AIR NAVIGATION, AIRSPACE AND AERODROMES BRANCH

CASA Ref: F23/1376-45

PROPOSED MIXED USE MOSTLY RESIDENTIAL BUILDING DEVELOPMENT EASTLAKES SHOPPING CENTRE 19A EVANS AVENUE - CASA COMMENTS

CASA has reviewed the Aviation Impact Assessment (AIA) Report by Thompson GCS of 28 May 2026.

Diagram 1: Diagrammatic Presentation of TIFPOP Surface

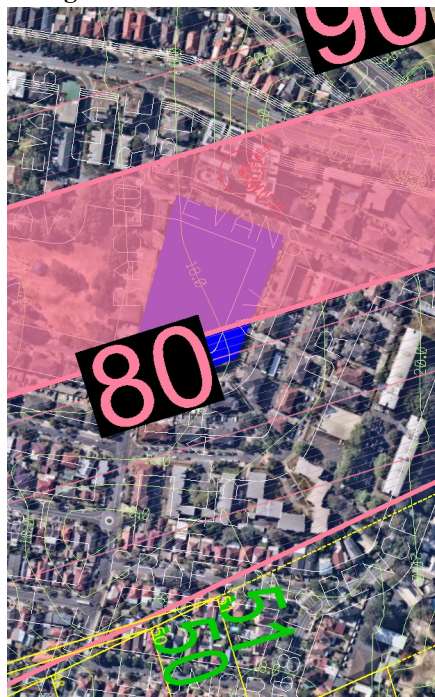
Since the previous assessment above, the PANS-OPS height has increased from a previous height of 60.6m AHD.

Permanent infringements of PANS-OPS / TIFPOP are not permitted. Above is a PANS-OPS snip from the Sydney Airport web page. It is difficult for a casual observer to interpret and could be out of date. It indicates PANS-OPS Horizontal Plane of 83.4m (except for maybe the SE corner of the site). The AIA indicates PANS-OPS is: *From 79m (southeast of site) but 83m AHD over most of the site*. It is important to get a definitive PANS-OPS assessment from Airservices Australia, as the designer of the

Instrument Flight Procedures (IFP). As the AIA correctly says: *Airservices' Procedure Design Unit (PDU) will confirm this height during their evaluation of the aviation application. They are final arbiter of the TIFPOP height.*

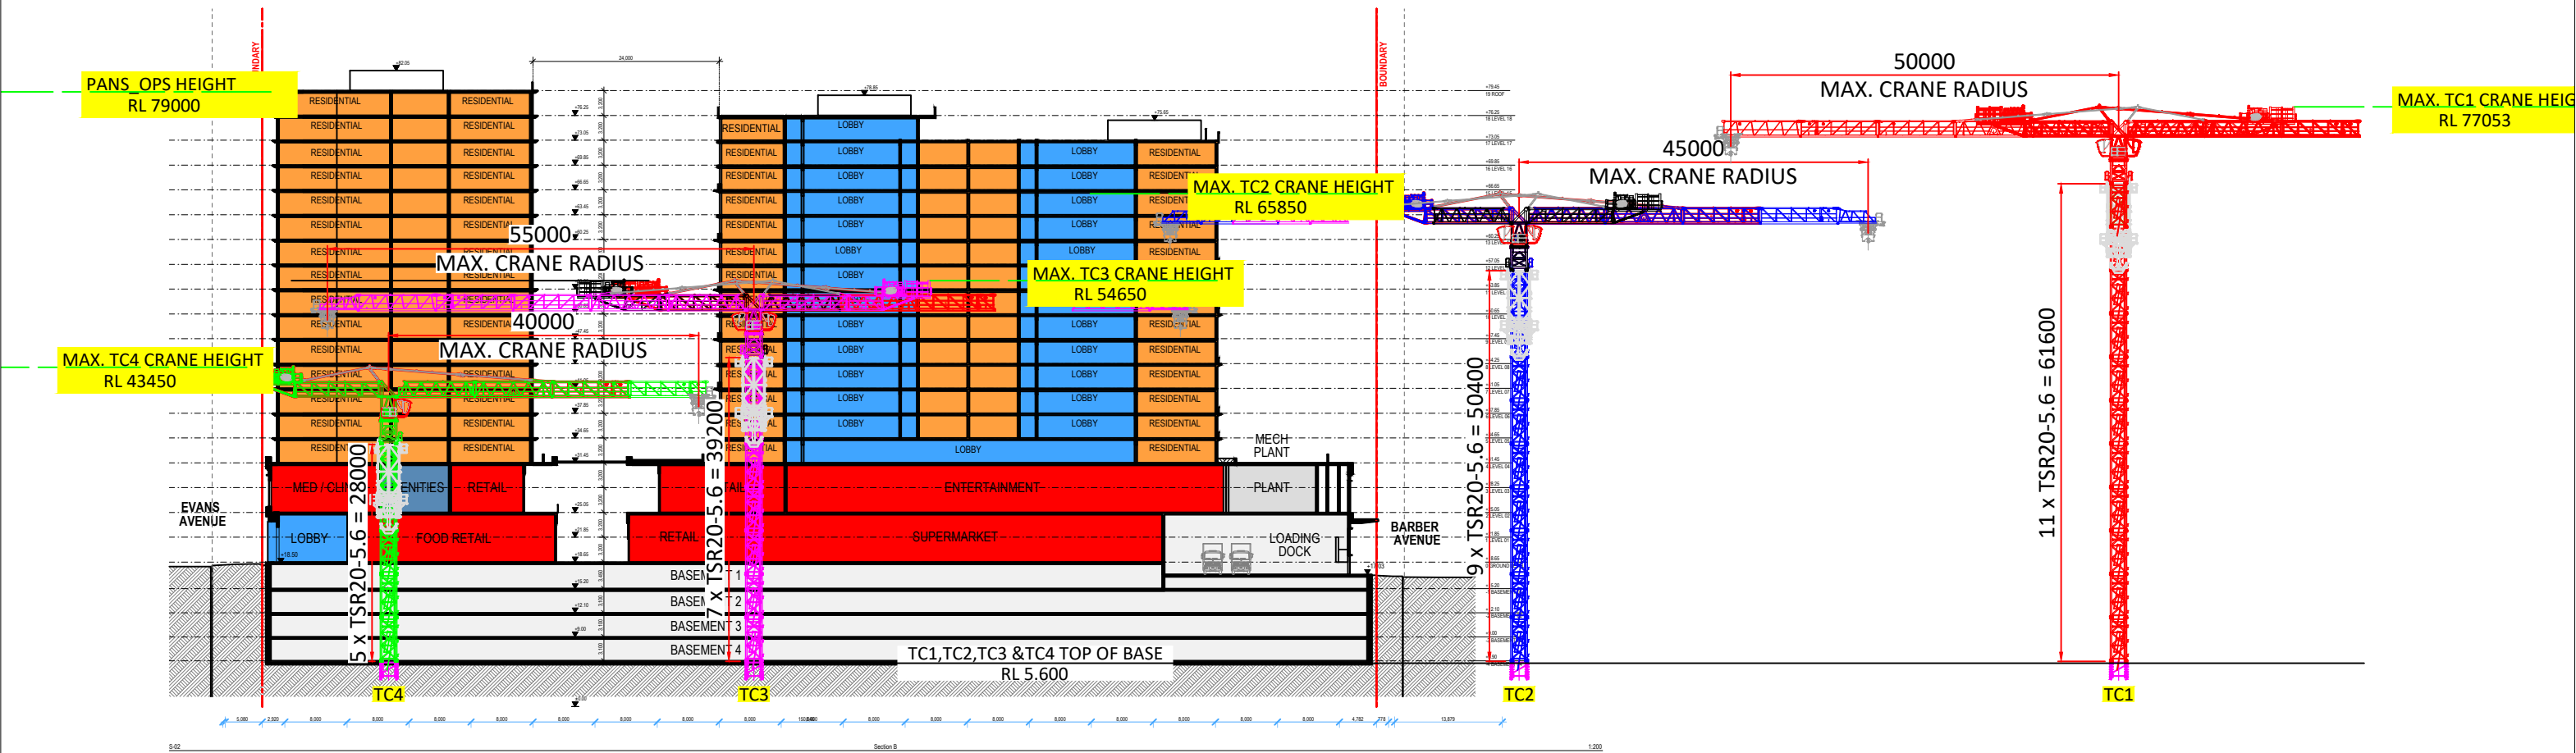
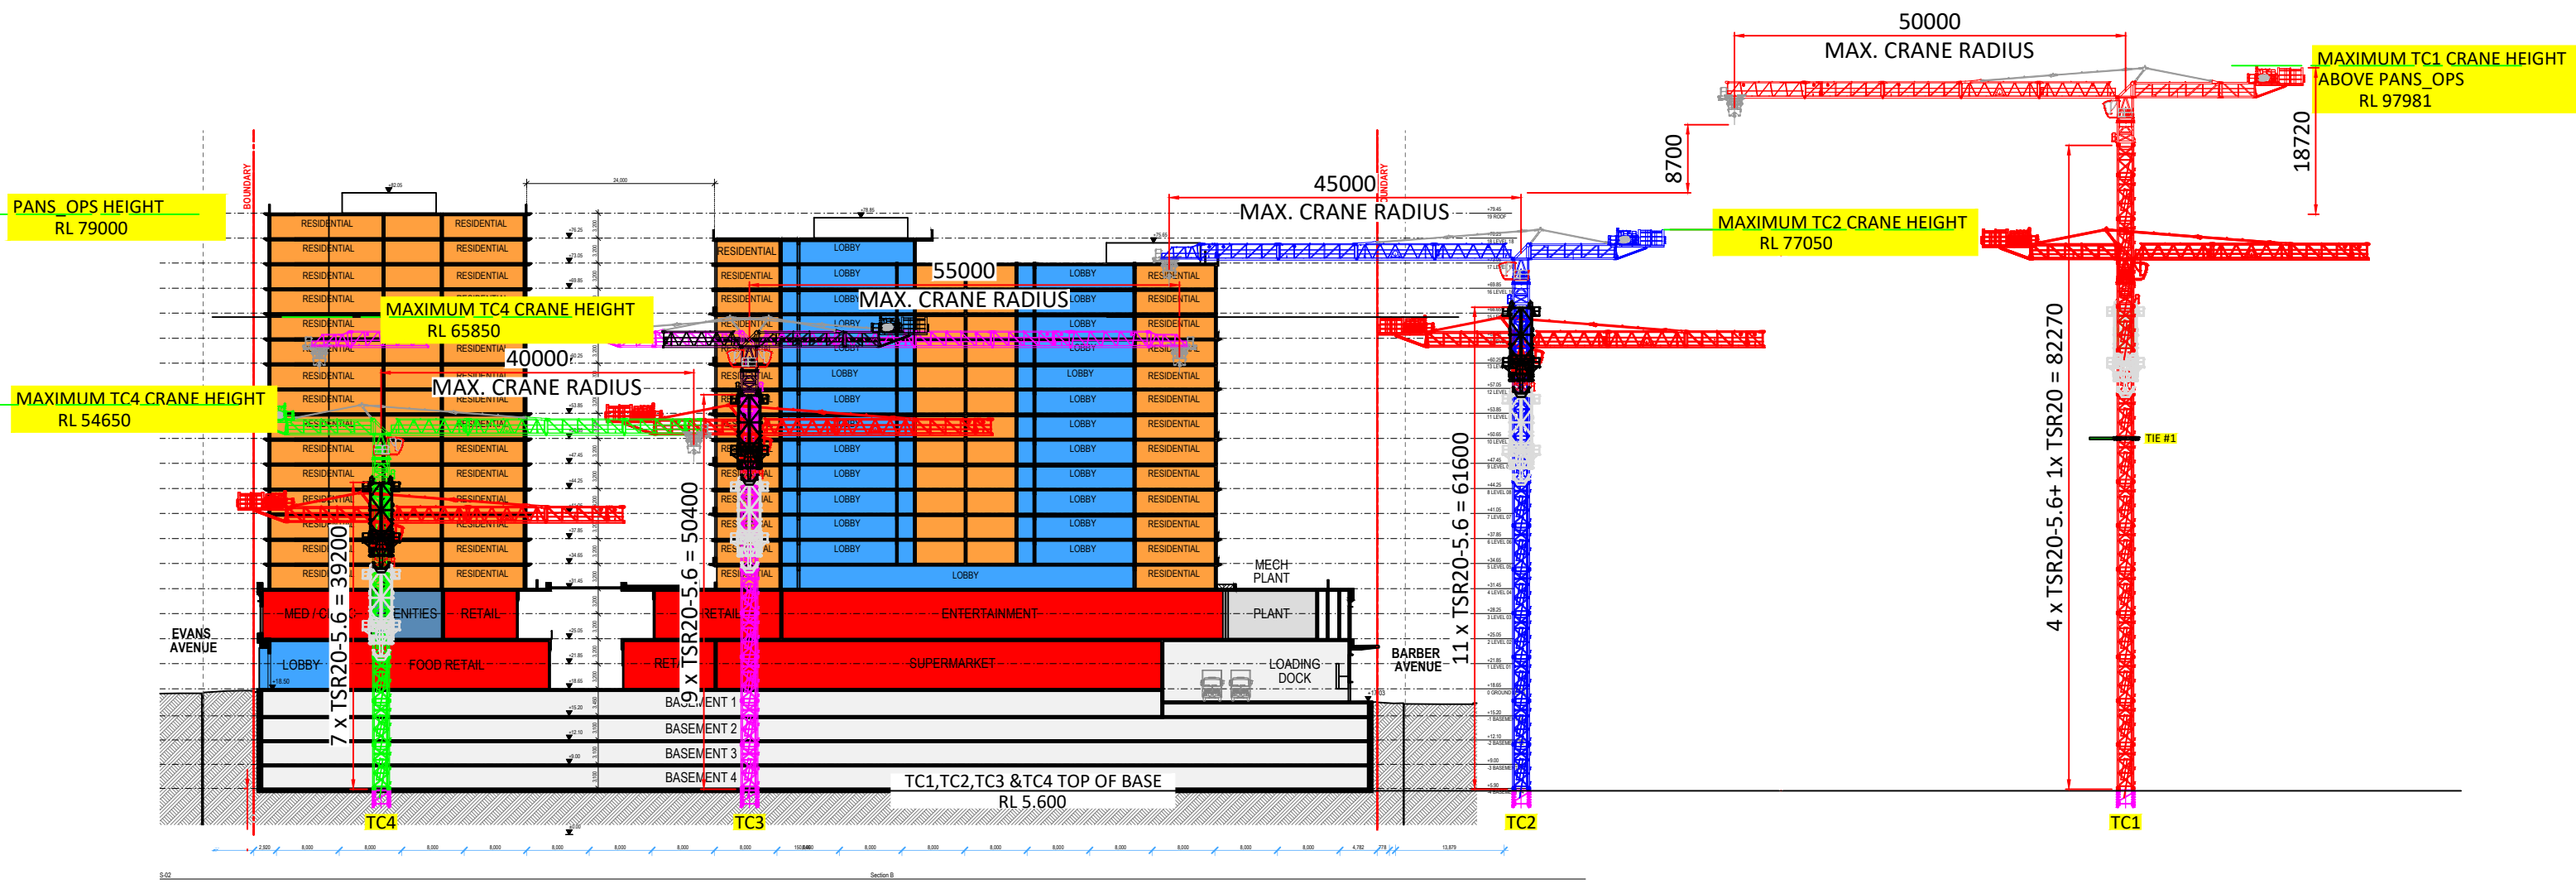
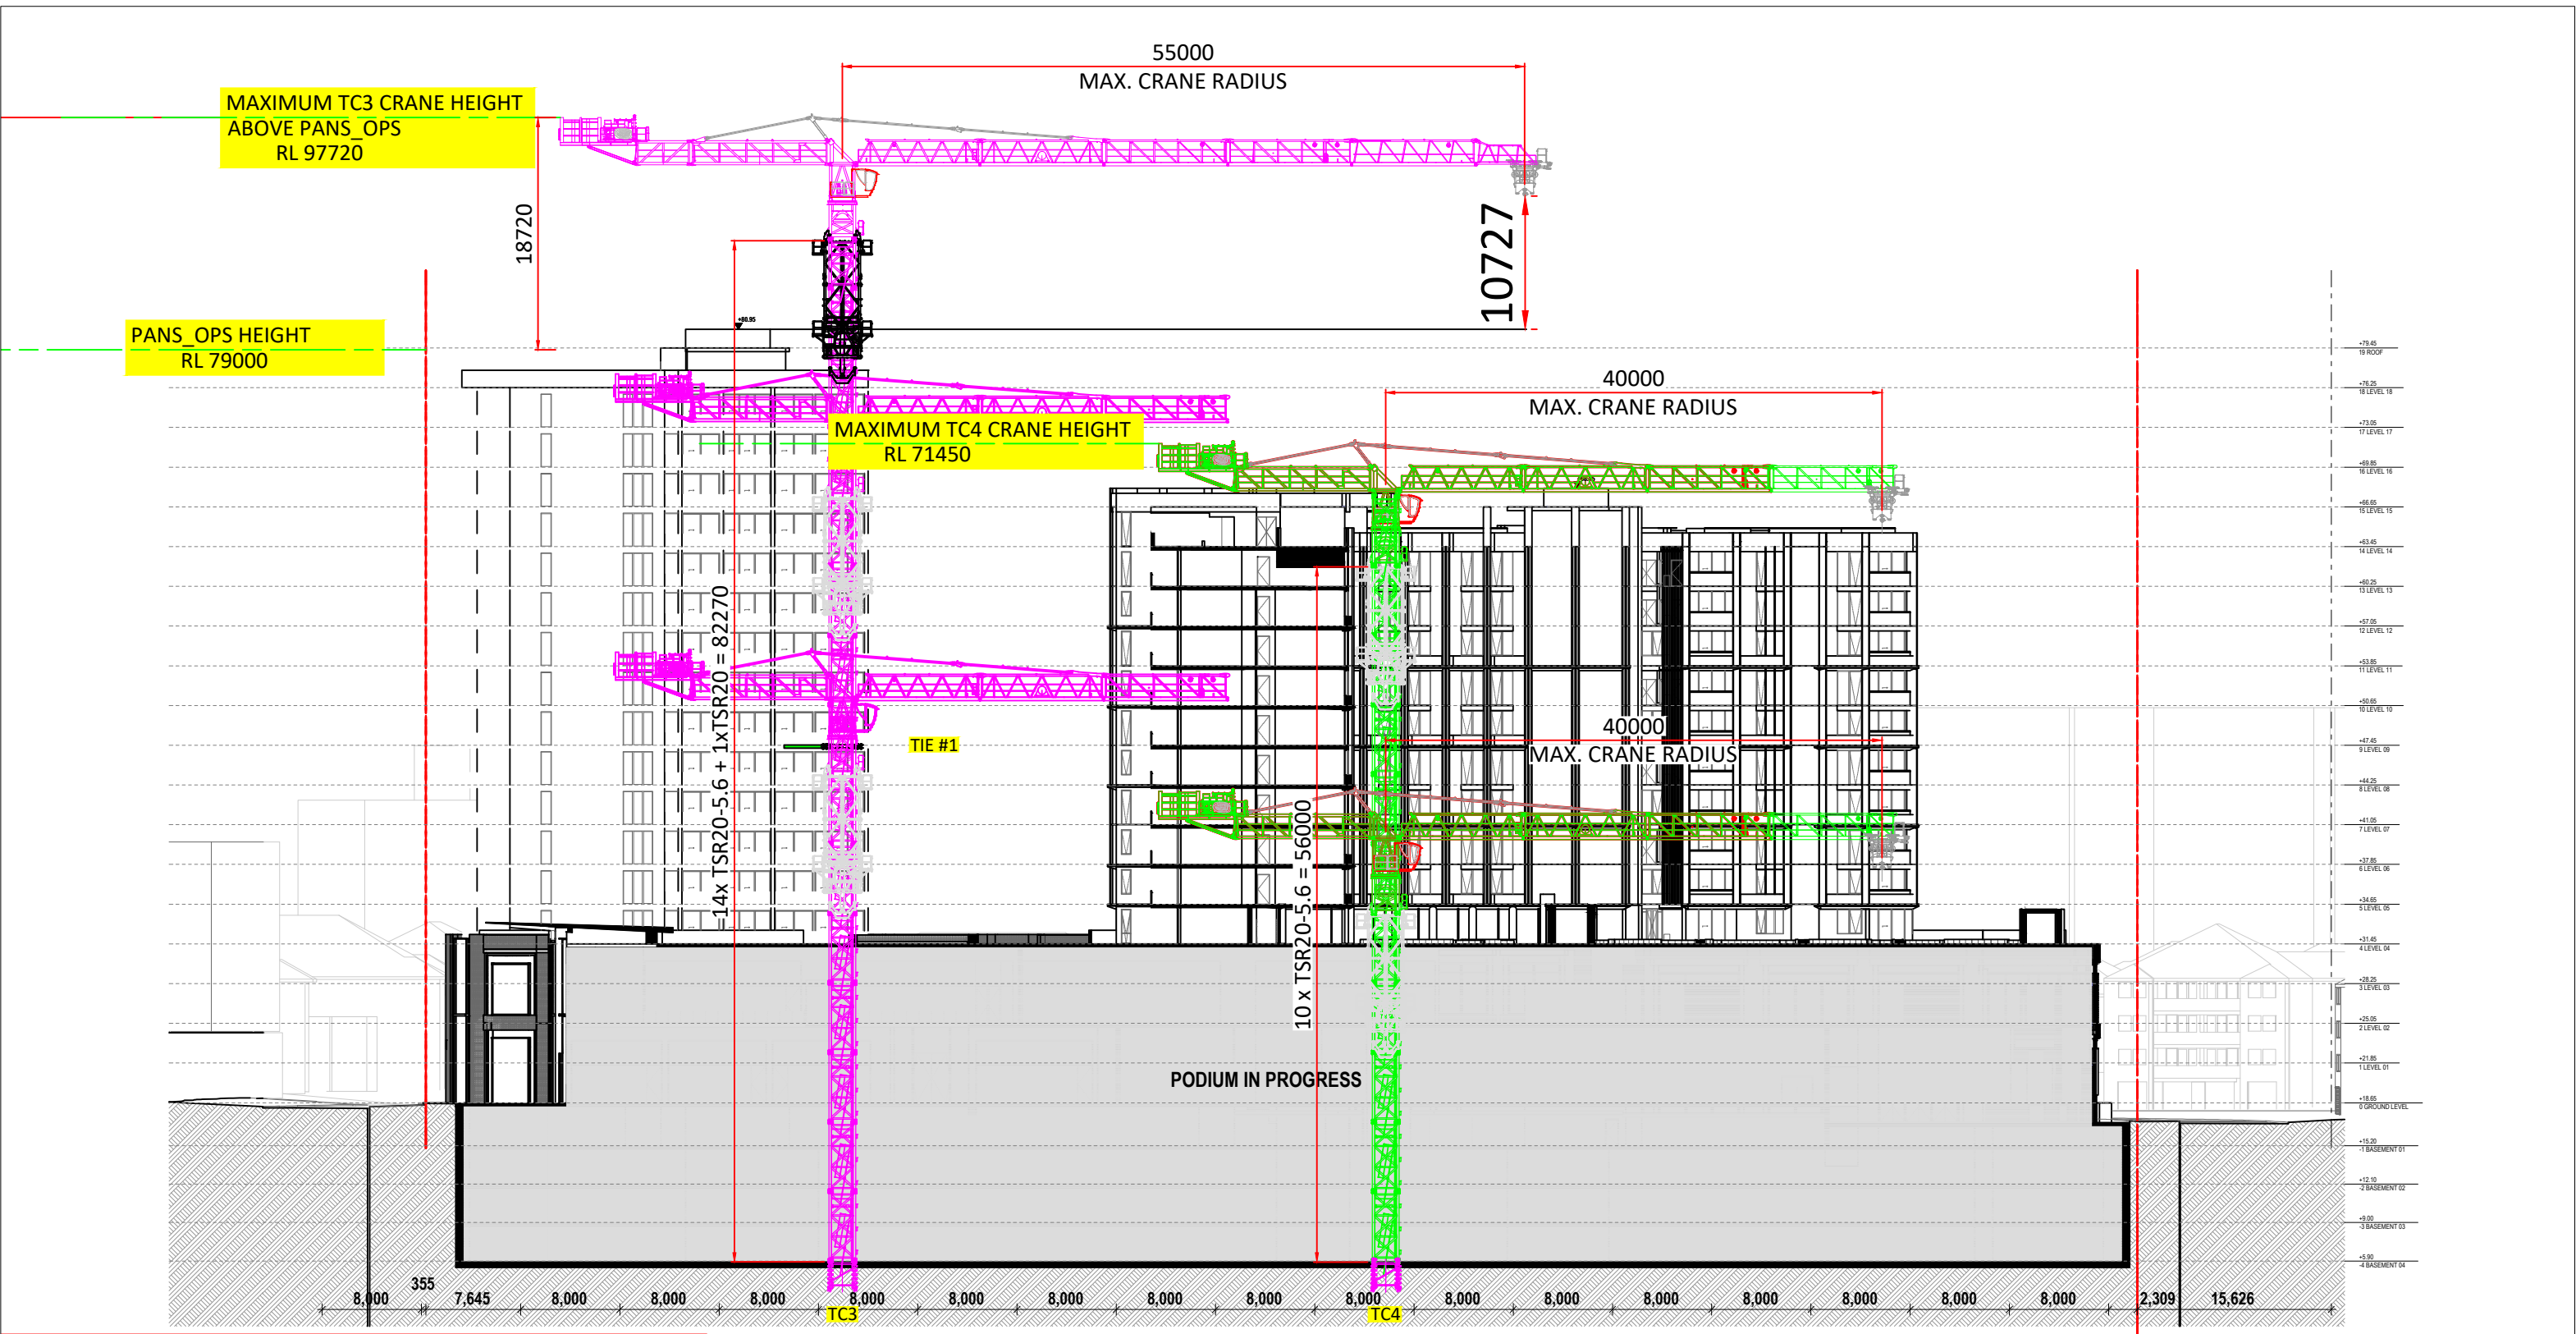
- The Department of Infrastructure will consider each tower crane as a temporary sensitive controlled activity;
- Airservices can mitigate the PANS-OPS / TIFPOP infringements by tower cranes;
- If the mobile crane infringes PANS-OPS / TIFPOP, it can be mitigated by Airservices adjusting IFPs and / or Sydney Airport adjusting runway lengths;
- The buildings can be built safely / in accordance with the Airspace Regulations ...

- the buildings (it is likely that CASA would recommend obstacle lighting on the tallest building noting that the tallest existing buildings in the vicinity are in the order of 9 storeys (and it is close to PANS-OPS).
- the tower cranes (obstacle lighting, obstacle marking, NOTAMs etc - to be finalised)
- the mobile crane(s) (obstacle lighting, obstacle marking, NOTAMs etc - to be finalised)

However, before CASA makes recommendations, CASA will need Airservices' assessment of the buildings and cranes.
